ISH 5 Hearing Action Points

London Pilots Council (LPC) Submission

5th March 2019

Figure 3: PLA Simulator extent (ESL Pilot Launch tracks also shown - demonstrating area of activity for North East Spit Station).

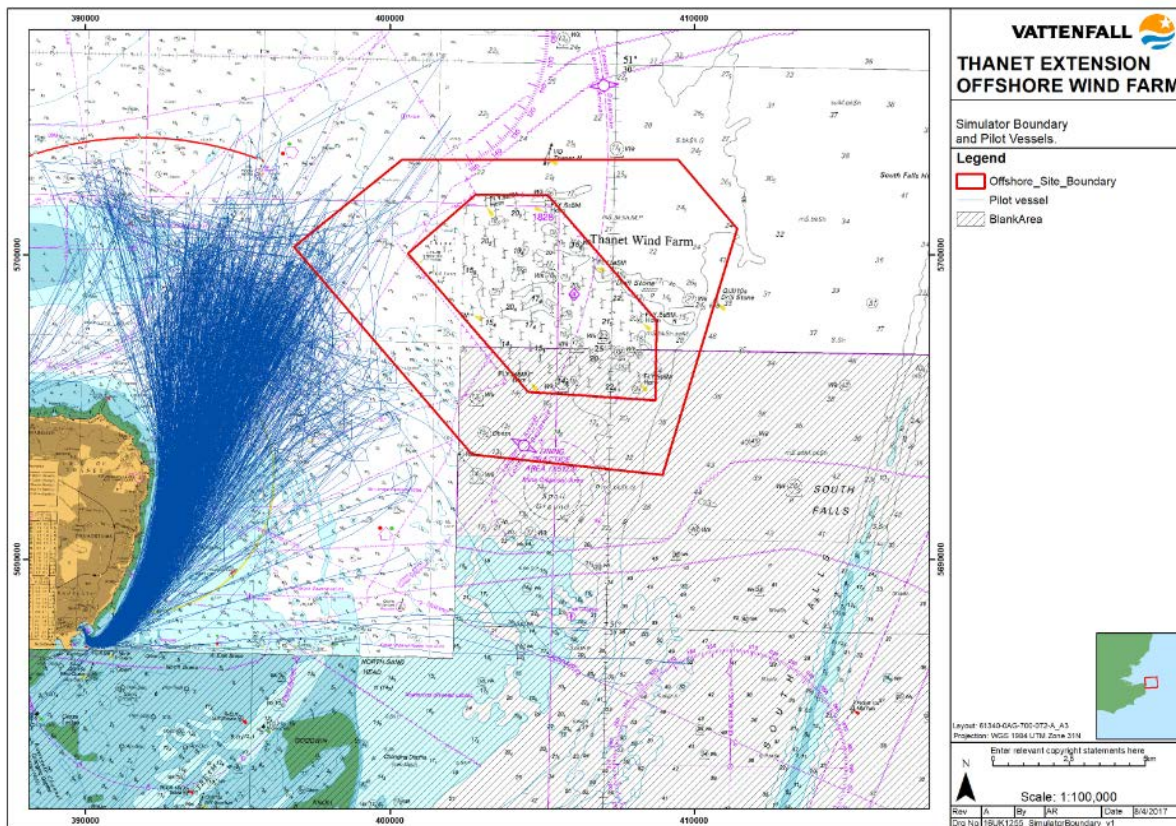
- 1.7. The Port of London simulator. The use of the PLA simulator to obtain the trial data can at best, in the opinion of the LPC, is deeply flawed. The PLA simulator is used as a training tool for Pilots to look at ship handling techniques, berth approaches, tug work and some emergency scenarios. All Pilots have experienced the superior facilities offered by either Wallingford or Marin in the Netherlands which can offer the required superior multi vessel navigation situations, weather effect, reduced visibility and manoeuvring conditions of different vessel types required for a credible NRA. In our opinion the PLA simulator was not fit for purpose for such a project as the Thanet Windfarm Extension NRA where data and a requirement for detailed and accurate simulations are critical to the decision making process.

Sea Zones Plan – Reduction in red line boundary

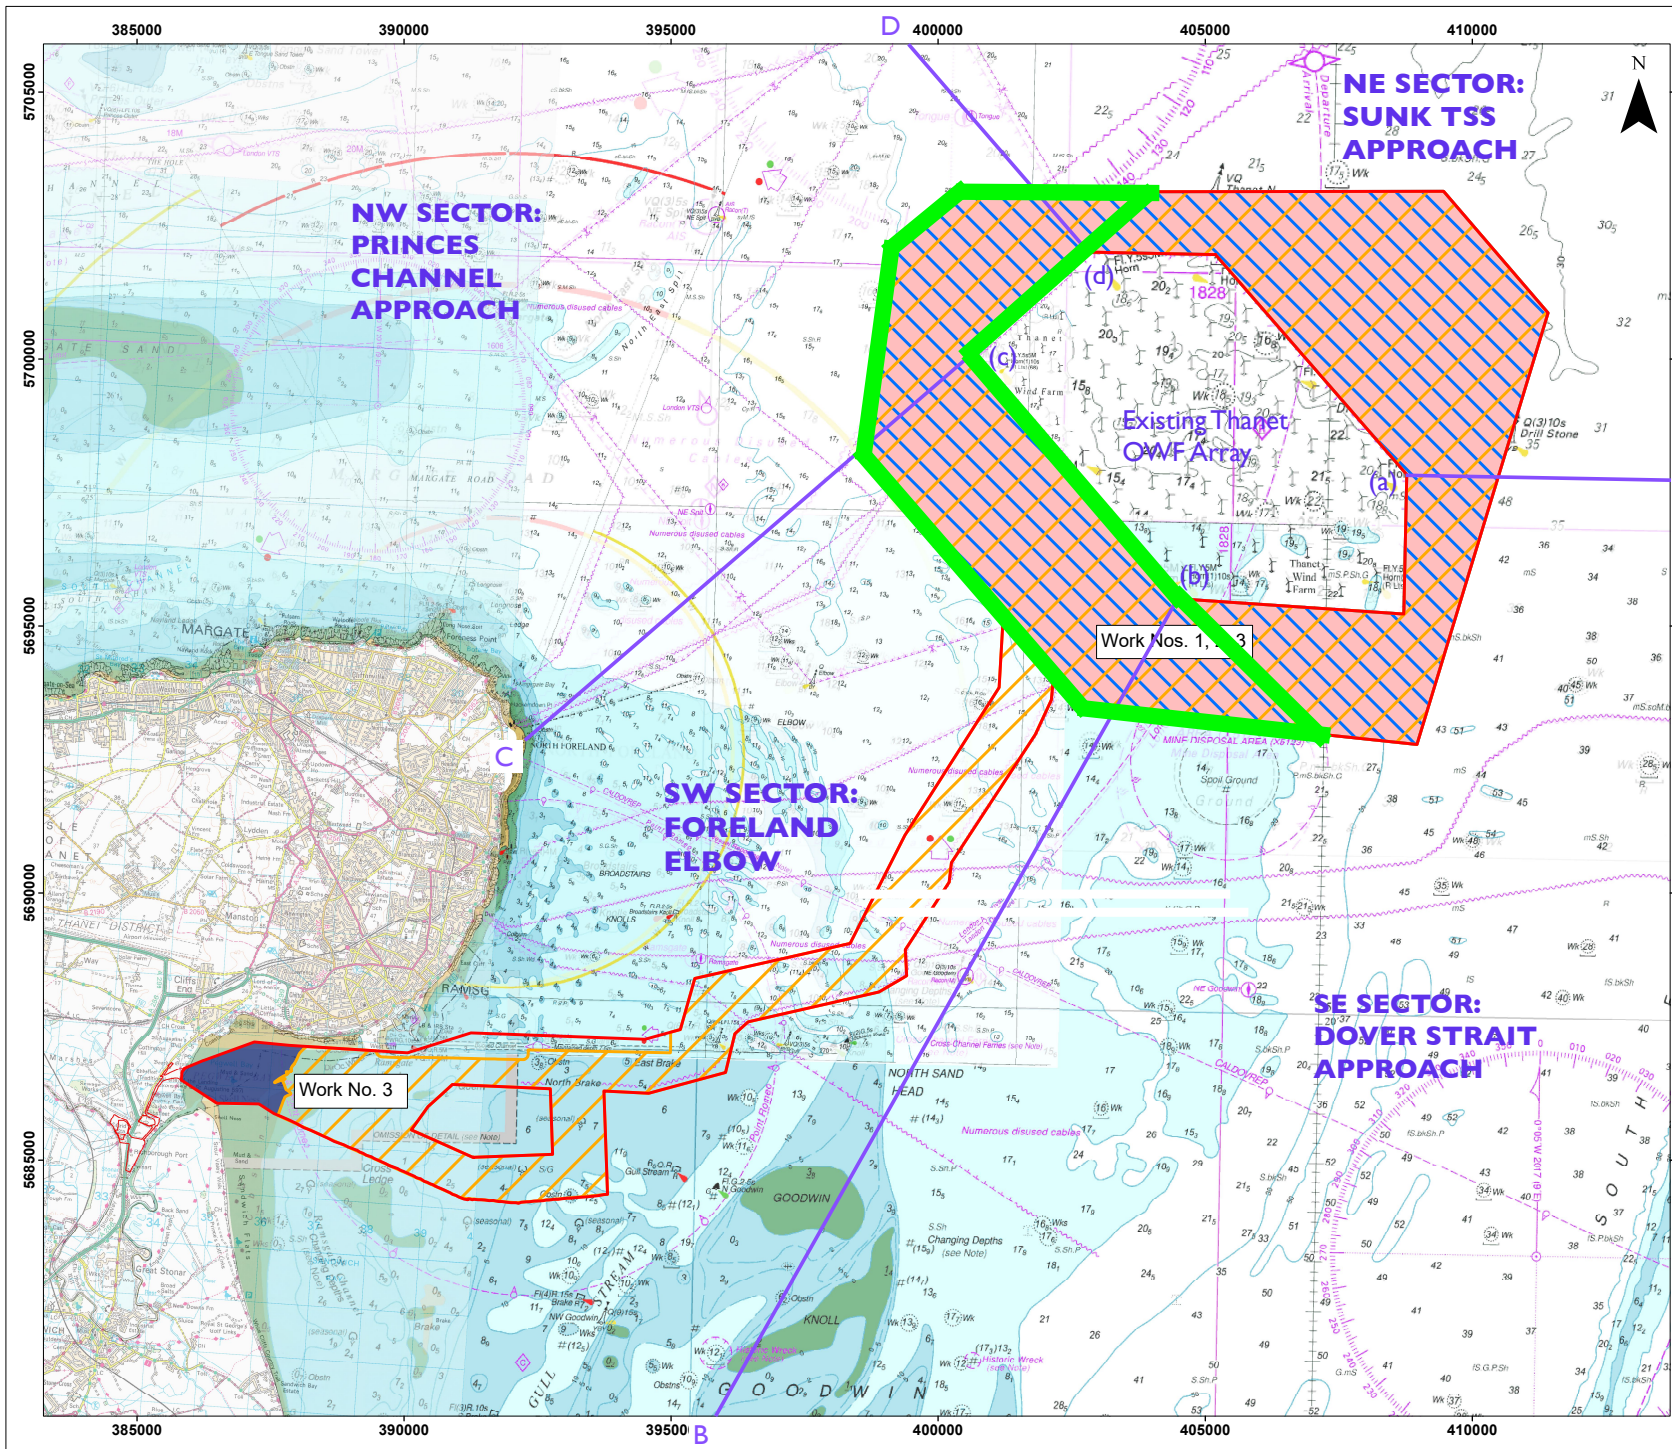
- 1.1. The remaining searoom at the NESP which the proposed red line boundary imposes for the general navigation of all vessel types transiting the sea area and for vessels engaged in Pilot boarding and landing operations remains the LPC's greatest concern

- 1.2. The exclusion zone or safety buffer. The minimum safe distance from the proposed red line boundary that general navigation and Pilot Transfers can safely operate. The Applicants 500m Safety zone is unacceptable.

1. 7.3.7 It is the opinion of the LPC as experienced Master Mariners that considering all of the above factors then a large vessel having selected a track to safely transit the NESP sea area which allows for adequate UKC and manoeuvring room for general navigation, would opt to be in the middle of the available sea room. Given that turning a large vessel at 10 knots requires 1 mile of sea room then an unrestricted sea room of at least 2 nautical miles eastwards from the NESP Racon Buoy and eastwards from the NESP boarding diamond and eastwards from the Elbow Buoy, to a yet to be determined exclusion zone, is required for general navigation and Pilot operations.
